ENG-PUDSP21010-R4-GEC.pdf Markup Summary

Subject: Callout
Page Index: 6
Date: 5/24/2022 6:16:28 PM
Author: CDurham
Color: ■
Layer:
Space:
Page Label: [6] 6 GRADING & EROSION CONTROL PLAN

G2.5

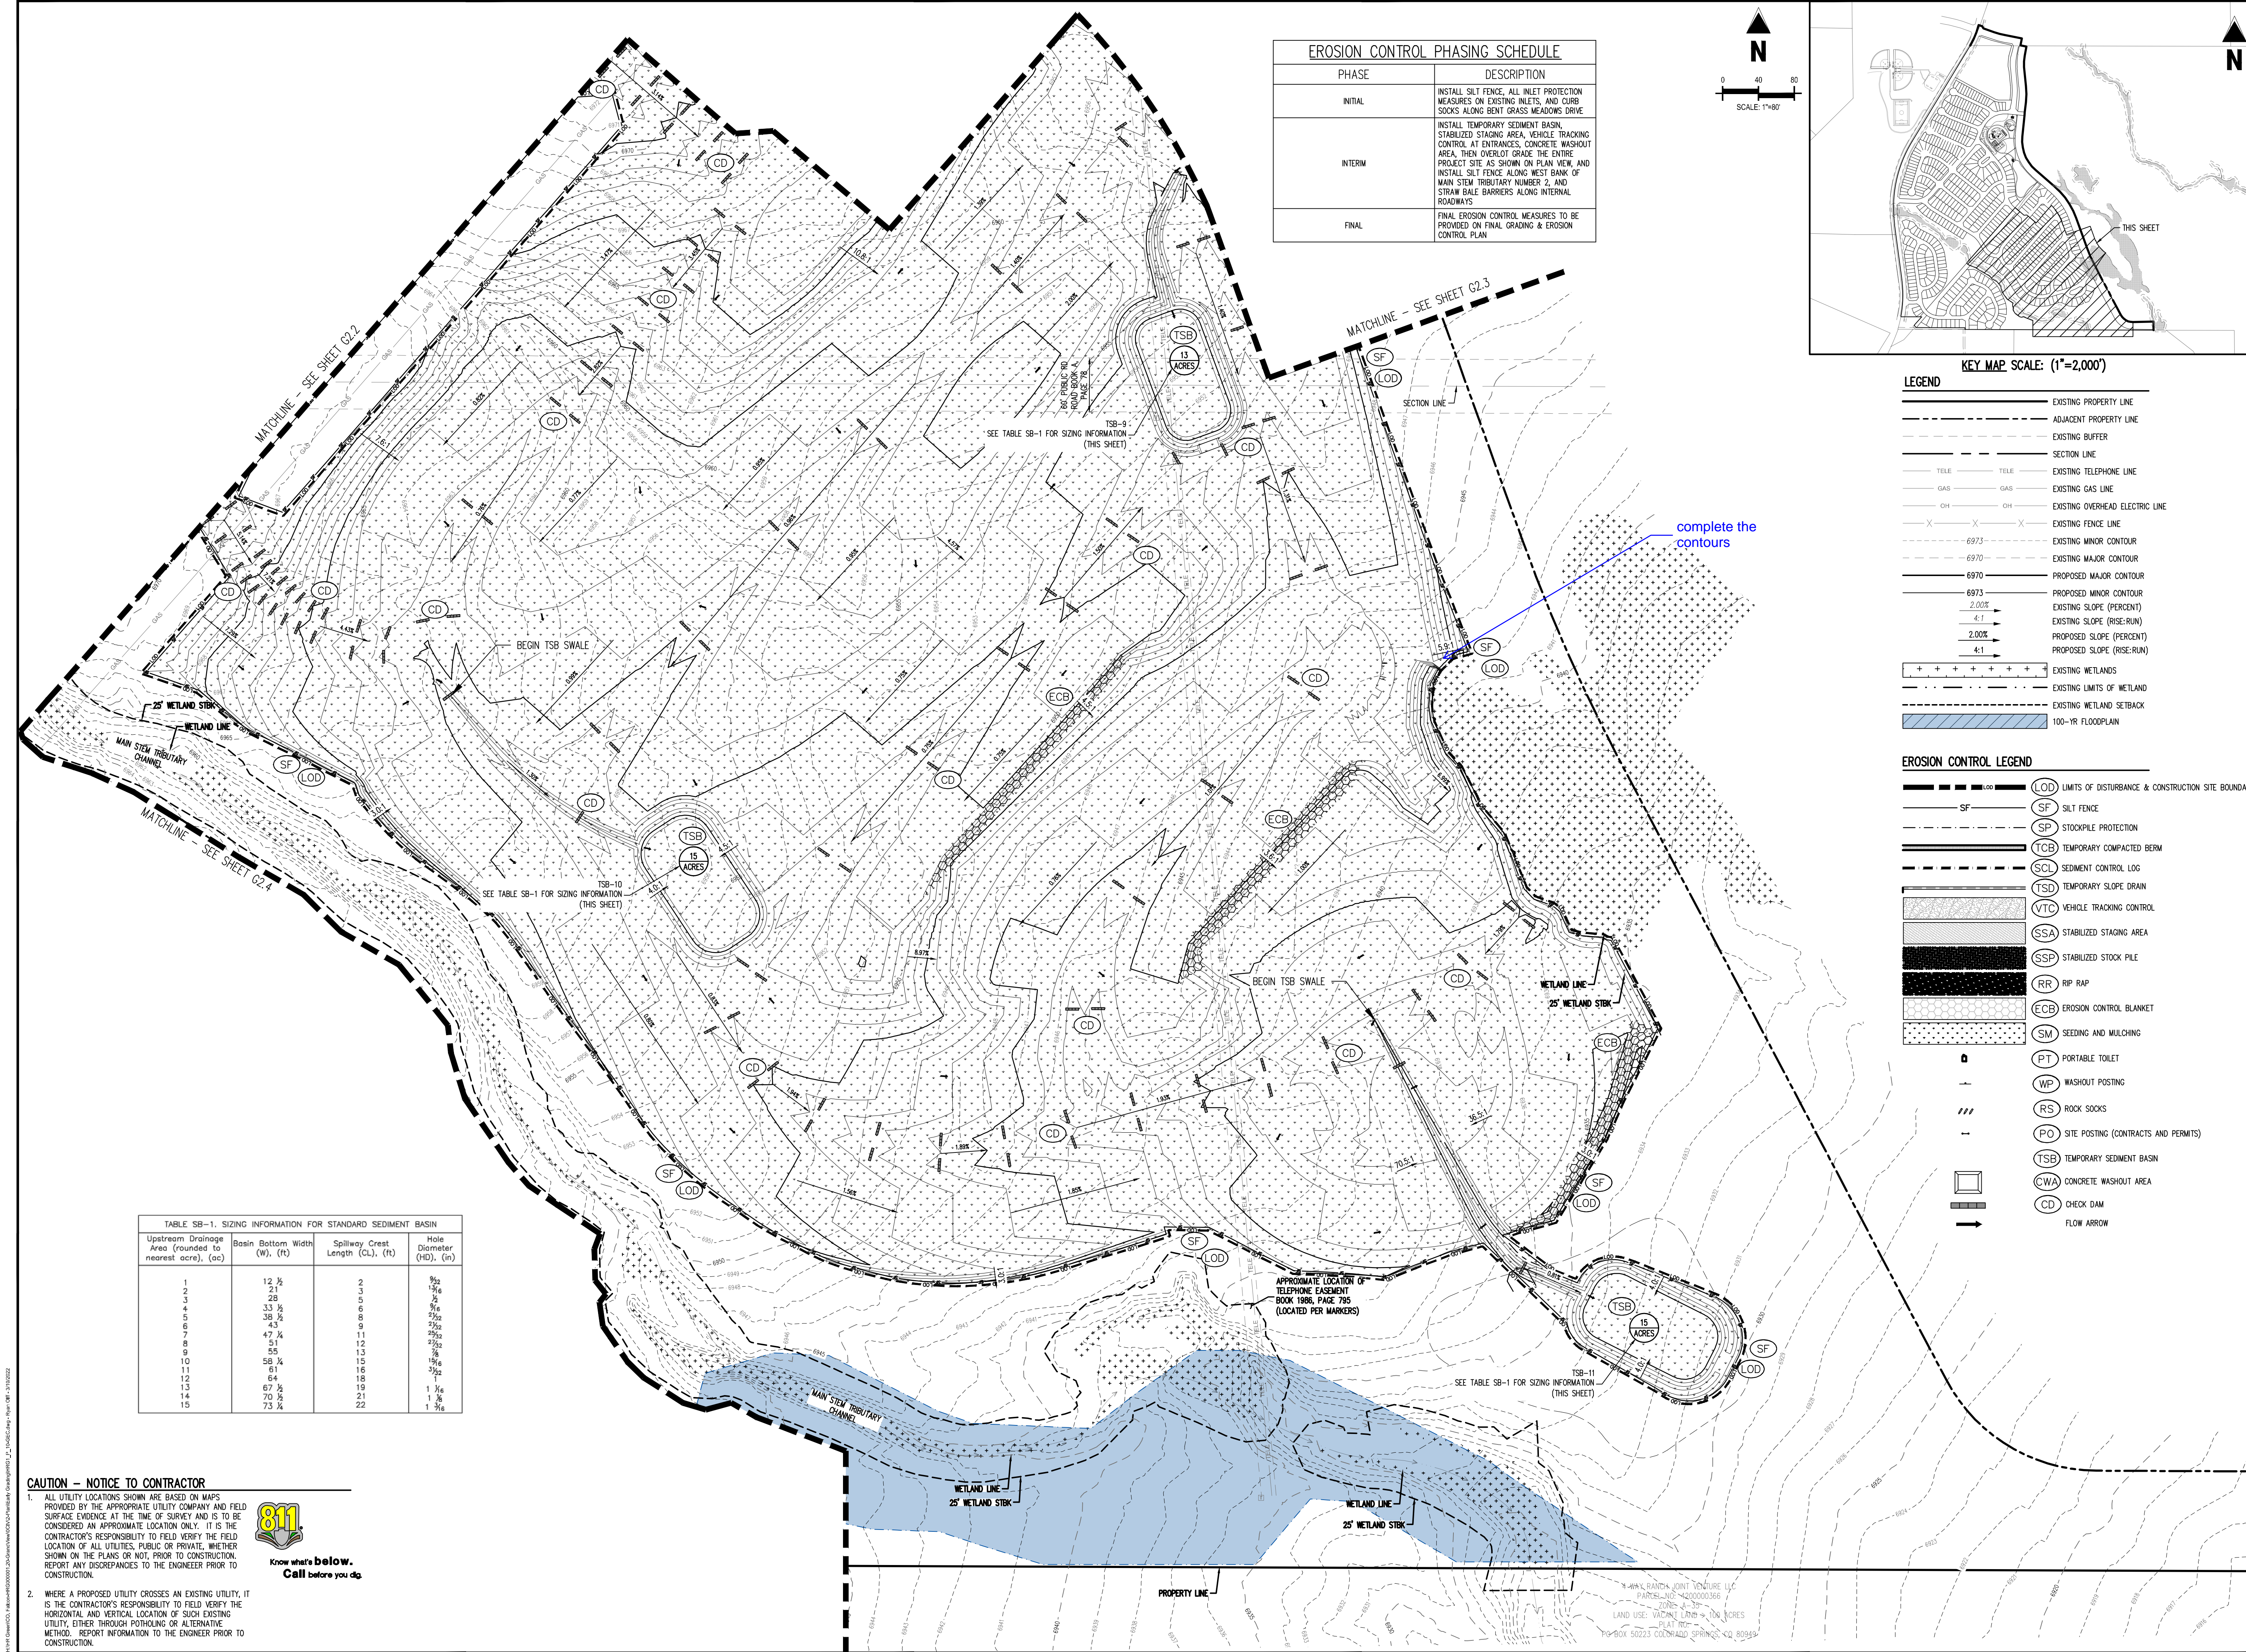
Is this a wall? Label if it is.

Why is ECB needed here?

Is ECB needed here?

## G2.4

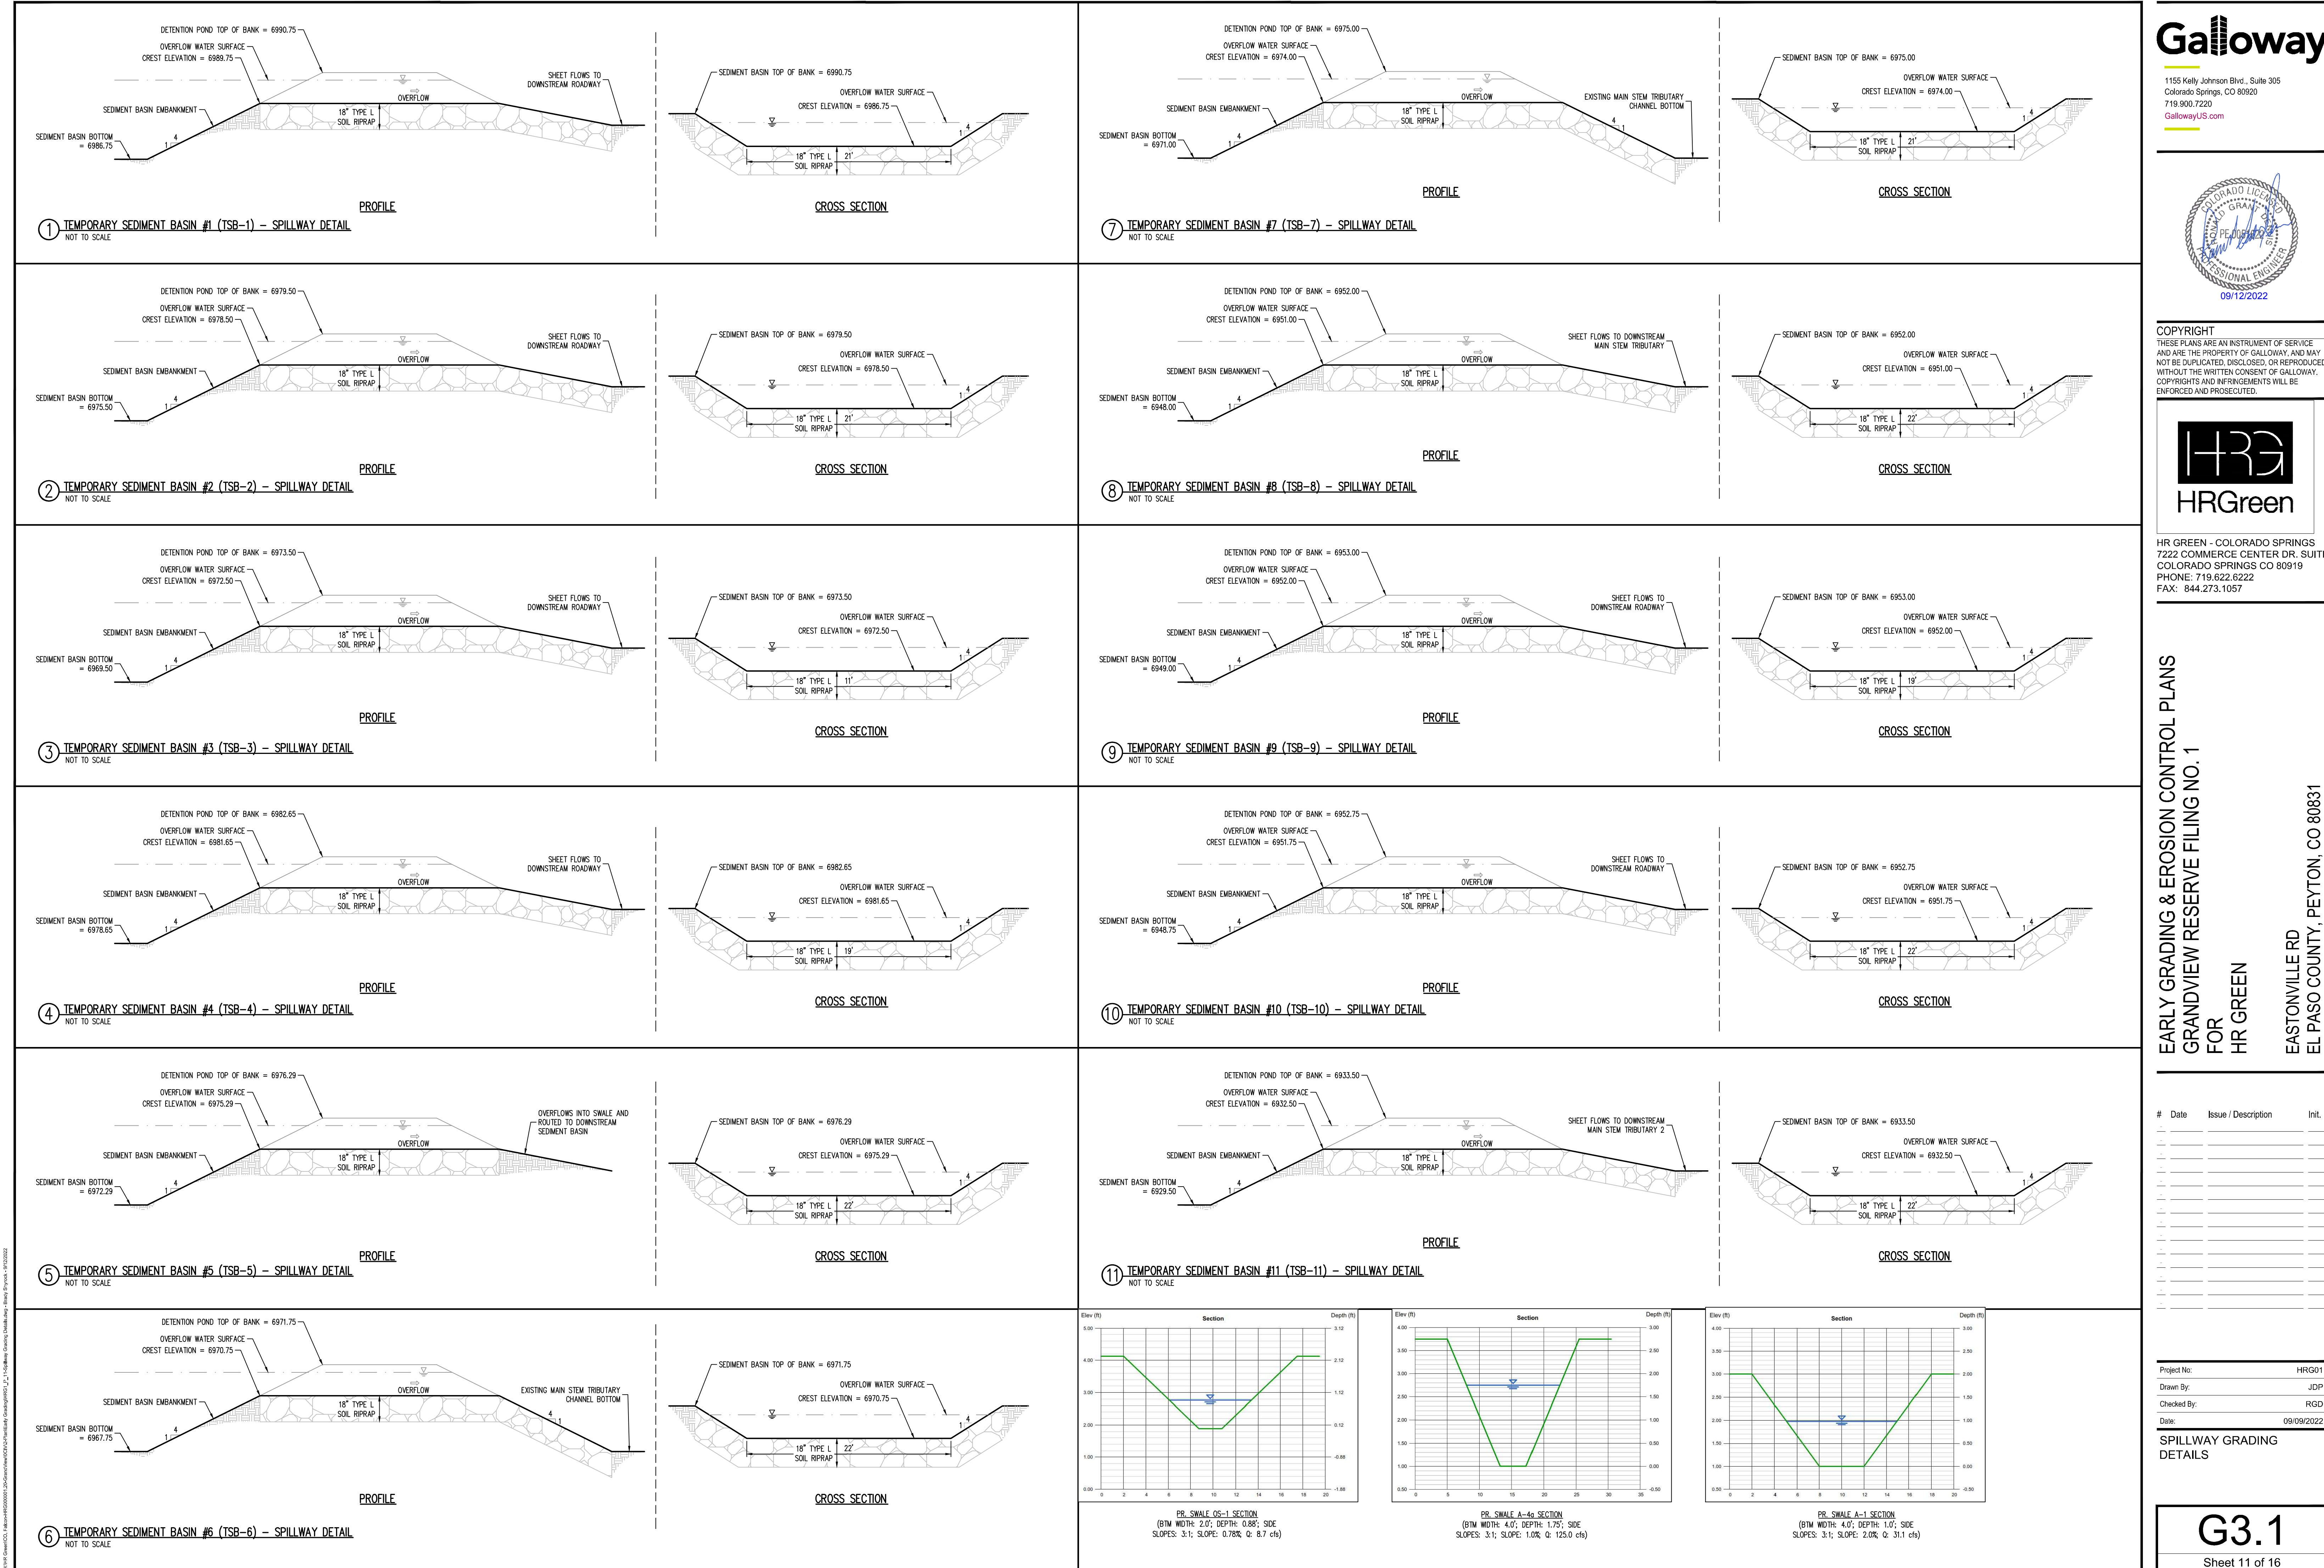
Fix slope label

Label culvert

Label culvert

Label swale

Why is ECB needed here?

Why is ECB needed here?

Label slope

Label slope

Verify that grading is complete and LOD correct

This ditch is new since V3.

Consider need for more erosion protection at the outfall than silt fence and a CD.

Silt fence not suitable for concentrated flows in this ditch.

Provide swale sizing calculations and cross-section in PDR (all interim swales)
